AB/82/20/L

83 Tarrant Street Arundel BN18 9DN

Listed Building consent to split bathroom into 2 to form en-suite and separate shower room, alter position of front en-suite shower room, change ground floor kitchen in to bedroom with en-suite, reconfigure staircase leading to basement & improve headroom, reduce level of floor slab to increase headroom & convert garage & storage area within basement into habitable accommodation to form open plan kitchen & living room with separate WC and games room, infill garage door opening with full height glazed doors, changes to fenestration, form external light well to front and replacement of existing windows to front and rear.

PROPOSED LOWER GROUND FLOOR PLAN

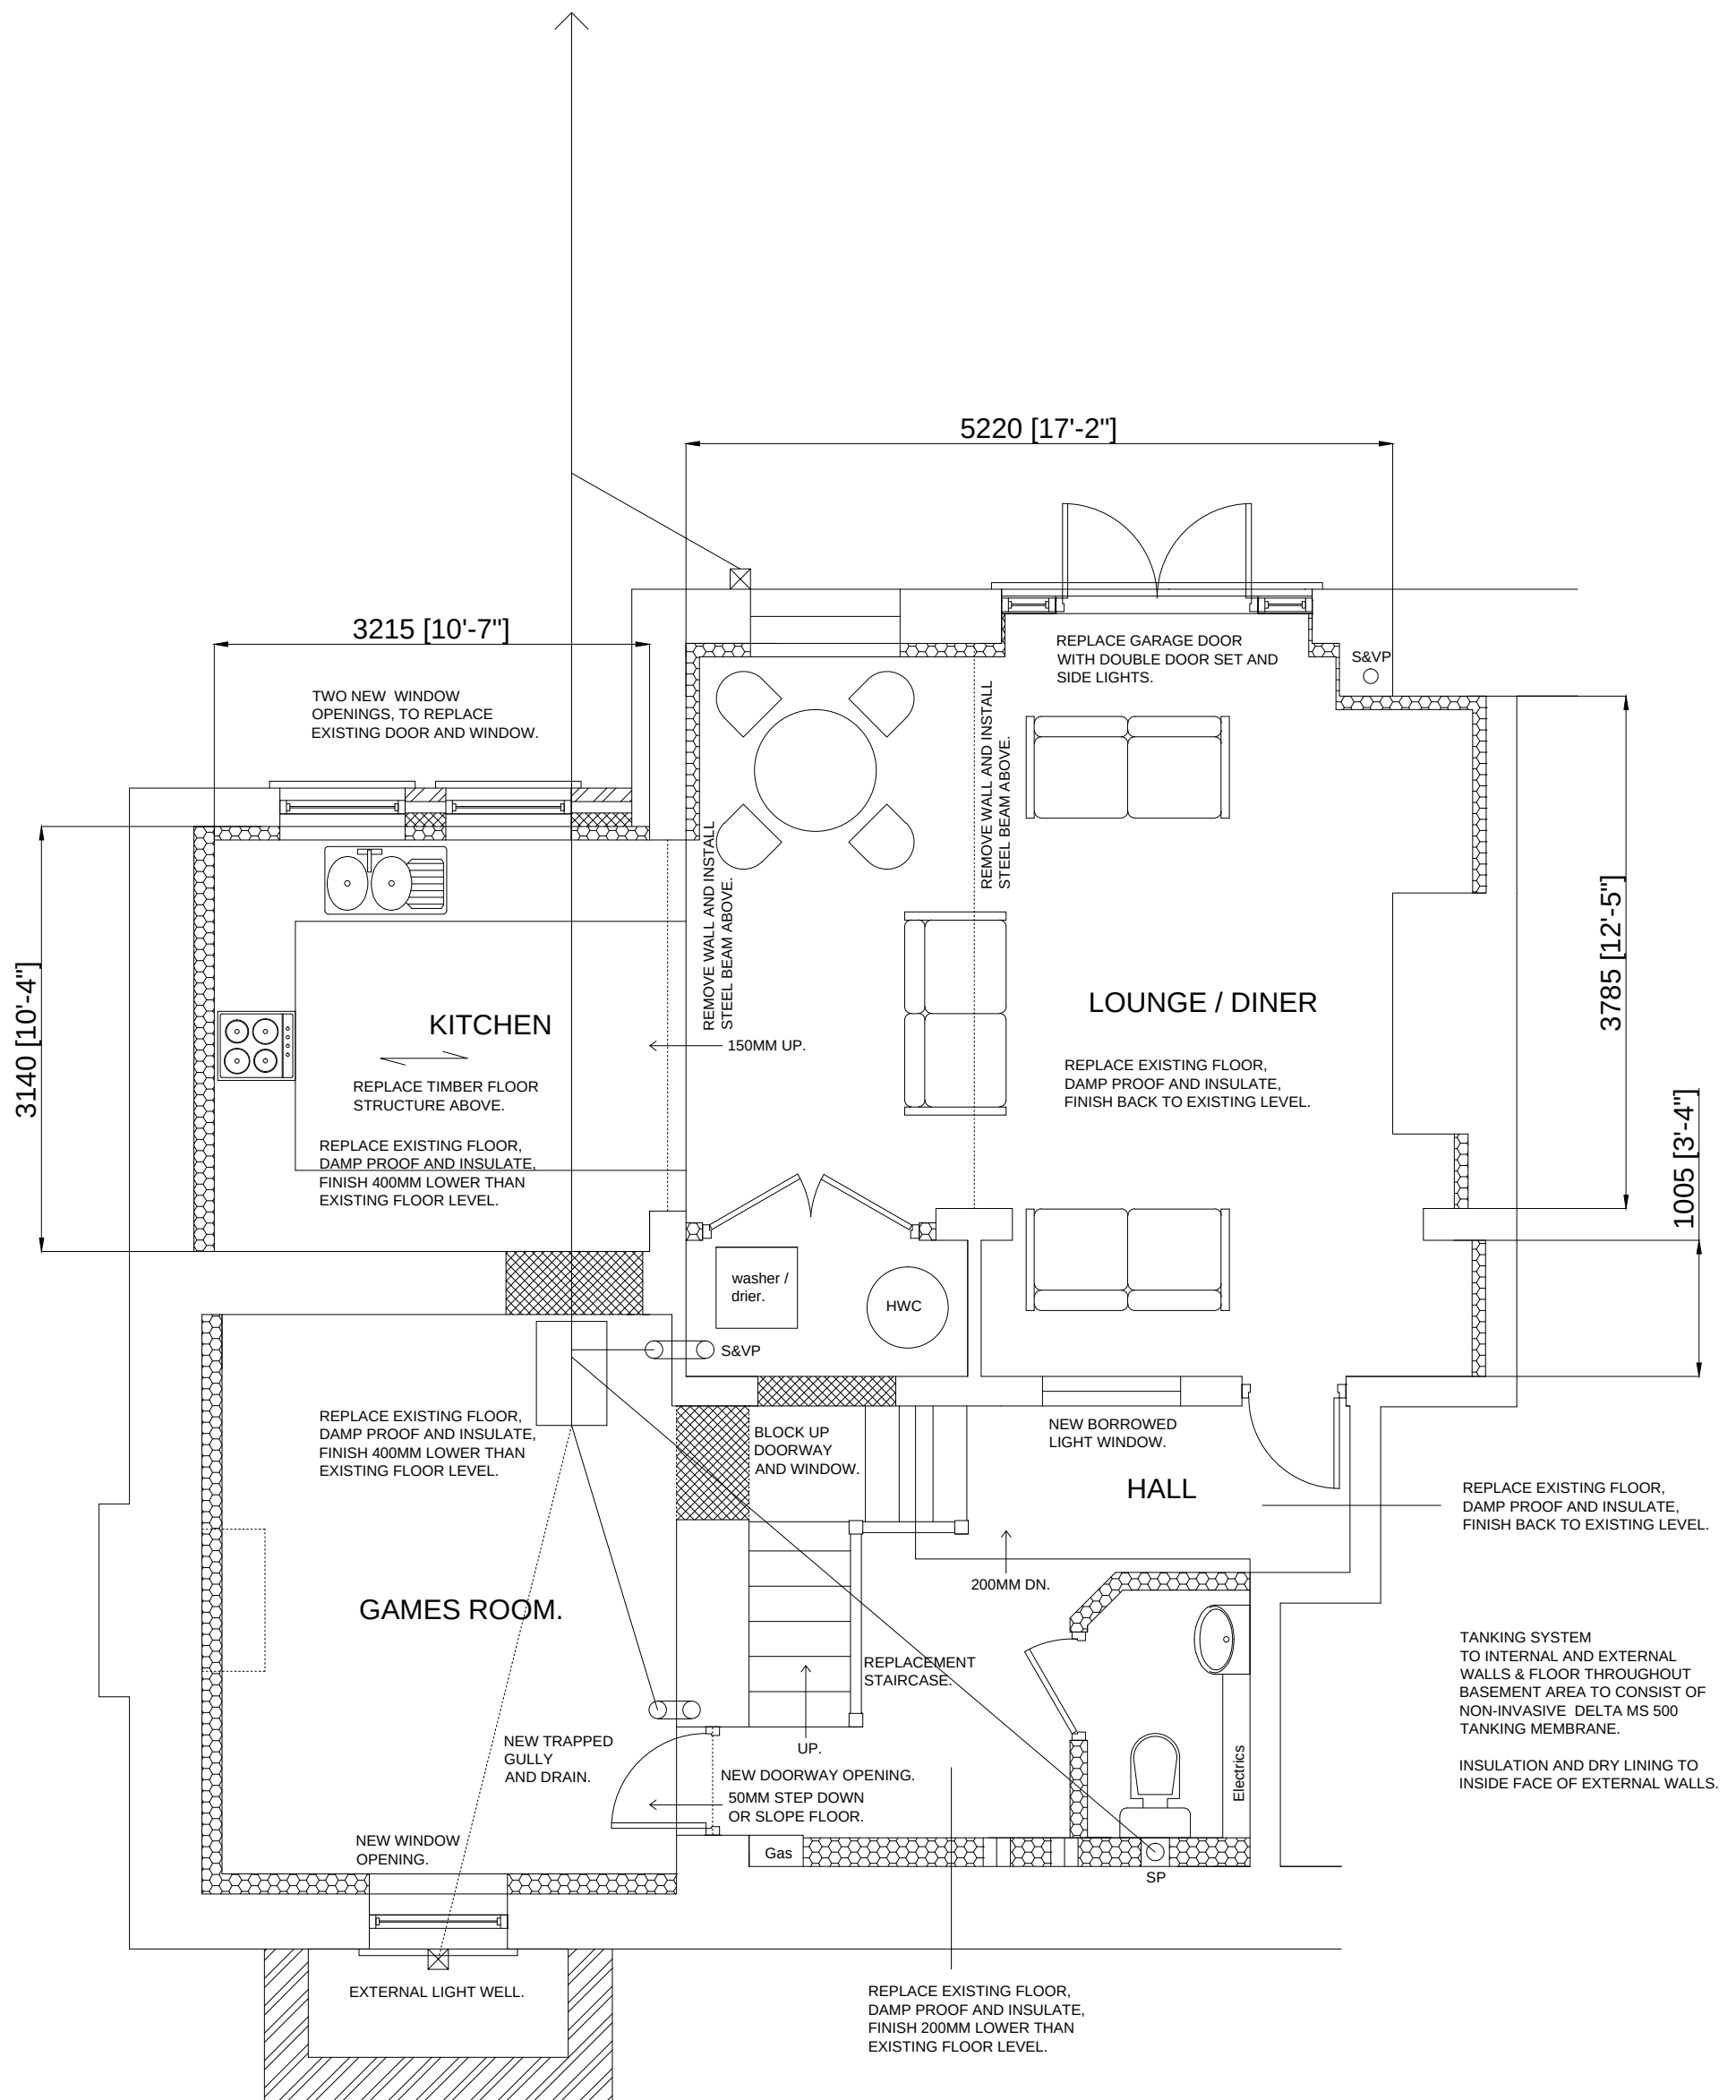
The internal alterations seem to be acceptable and appear to be designed so that they are reversible, should needs change in the future. Details of the new internal doors will be required as will the replacement stairs. I also require details of the internal window to be installed in the basement (and its treatment).

I also note that the plans/statements make reference to the fact that the head height to workshop 2 area will be improved further by replacing the timber floor structure above with shallower timber joists, combined with some steelwork. Will this affect any historic fabric, and what material will be used for the flooring in this room – will it be floorboards?

DRW NO 9 SCALE 1/10 (A3)
EXISTING REAR WINDOWS
ELEVATION / SECTION.

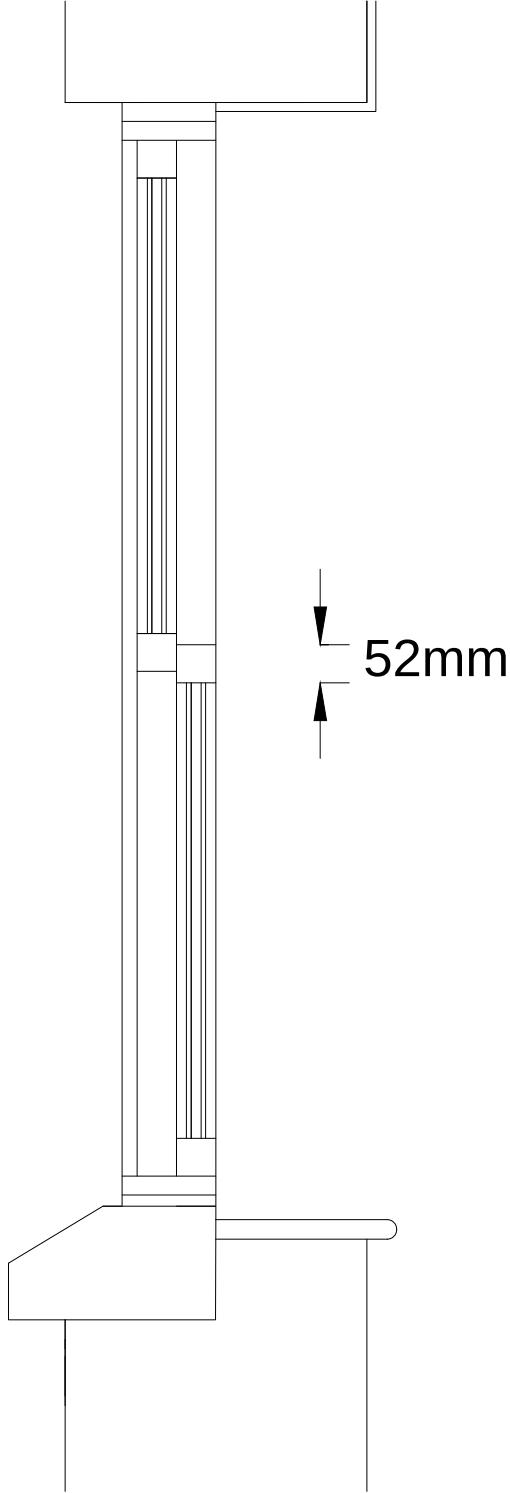
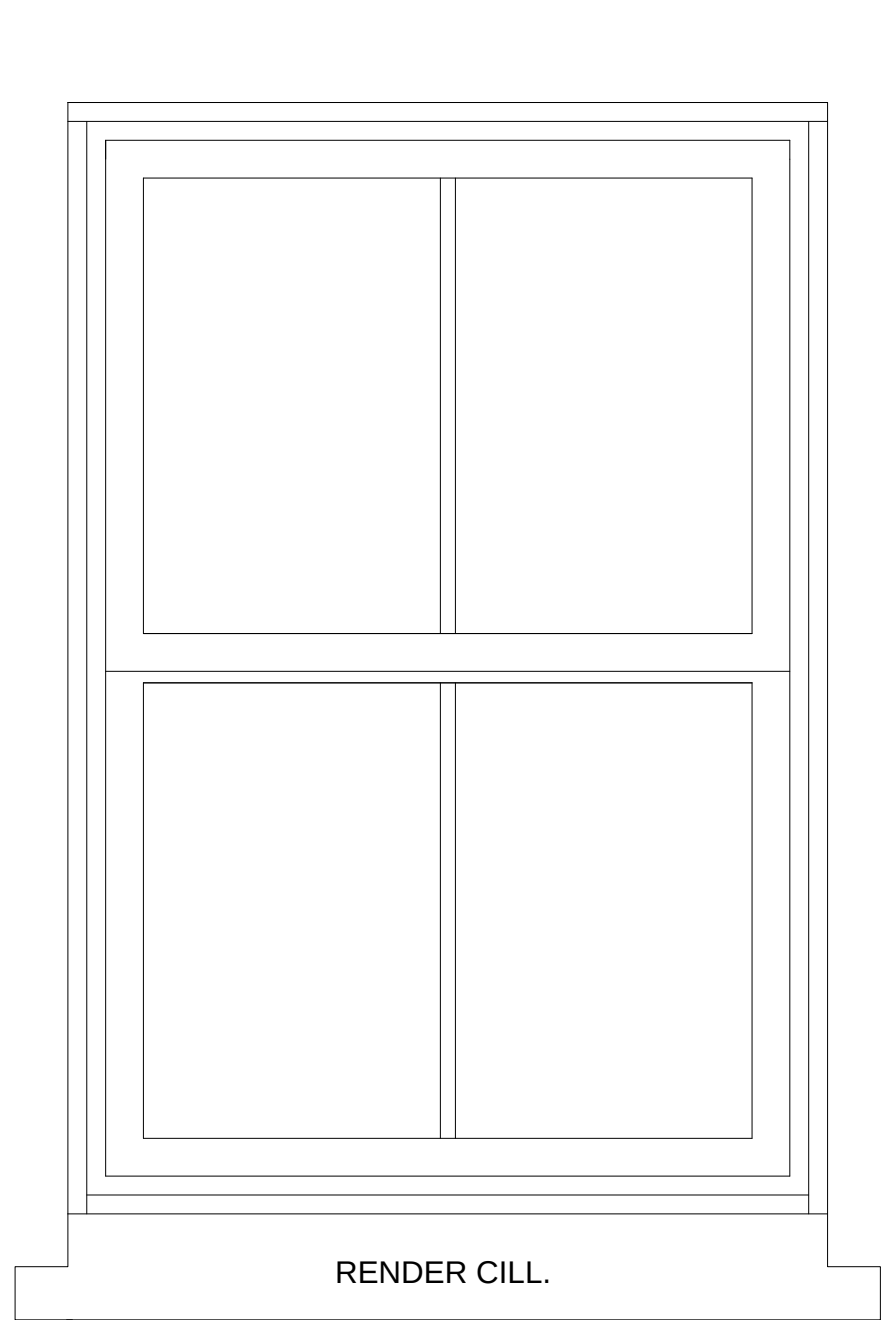
It is positive to note that all of the existing non-original alloy framed double glazed sash windows would be replaced with bespoke made wooden sliding sash windows with slender profile Georgian glazing bars. Such a proposal would form an enhancement to both the building and the conservation area, and is identified as acceptable in the latest guidance from Historic England.
